From: planning
Subject: FW: Consultation on Planning Application 3/2016/0236 and 3/2016/0238 Meeting House Sawley Raod Grindleton BB7 4RS For attn Adrian Dowd

The application is for: Grade II Listed Quaker Meeting House , with an attached cottage for which approval is sought to combine into a single domestic dwelling. This will involve internal alterations to form new openings between the existing cottage Scullery and Meeting House Disabled WC, conversion of the existing Meeting House Kitchen into an Entrance Hall and Cloaks Cupboard and the opening up of the wall between the existing Kitchen and Sitting Room of the Cottage to form a large Kitchen/Dining Area.

Proposed Plans

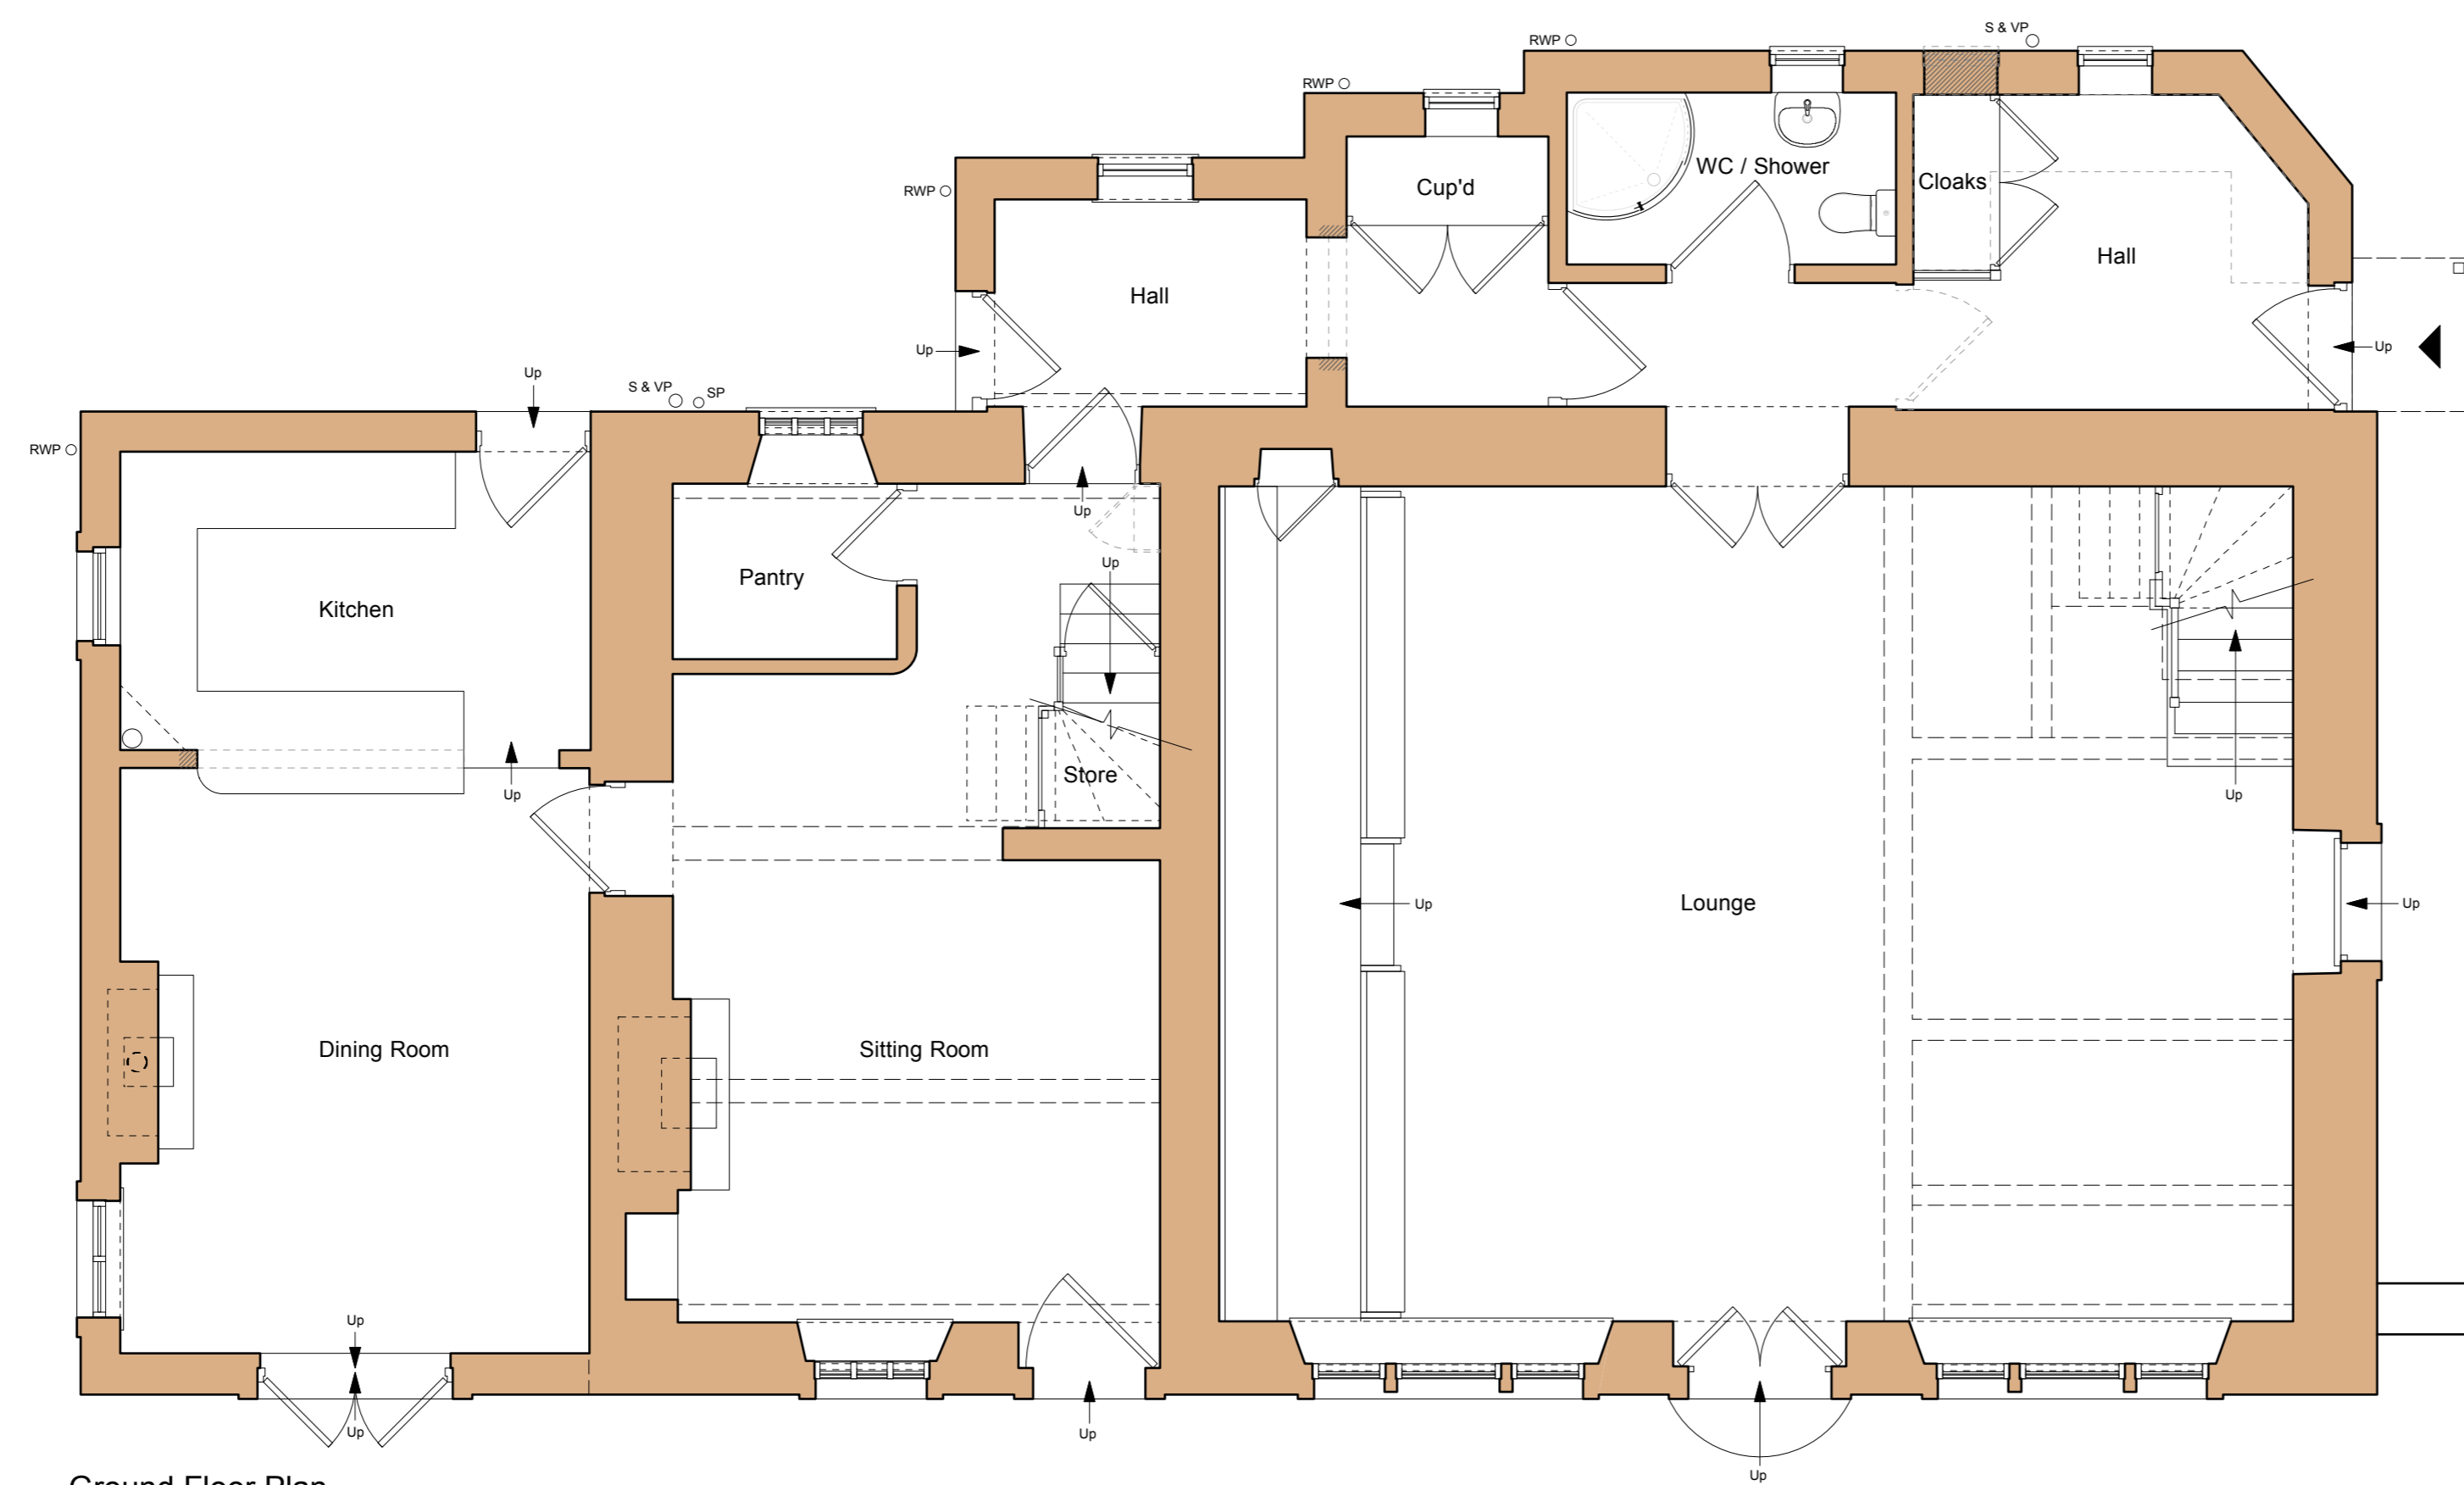
Comparison between the Existing and Proposal drawings implies that no alterations at all are in prospect for the interior of the Meeting House itself. This is of course welcome but is that really the case ? Is the seating which is very important to the simple but evocative character to be wholly retained ? . It is important too that the enclosed nature of the gallery (with its flap) is preserved as this is pivotal to the gender differentiation which is so fundamental to the historic character.

There are no plans as proposed of the whole site – will there be any changes to the historic setting ?
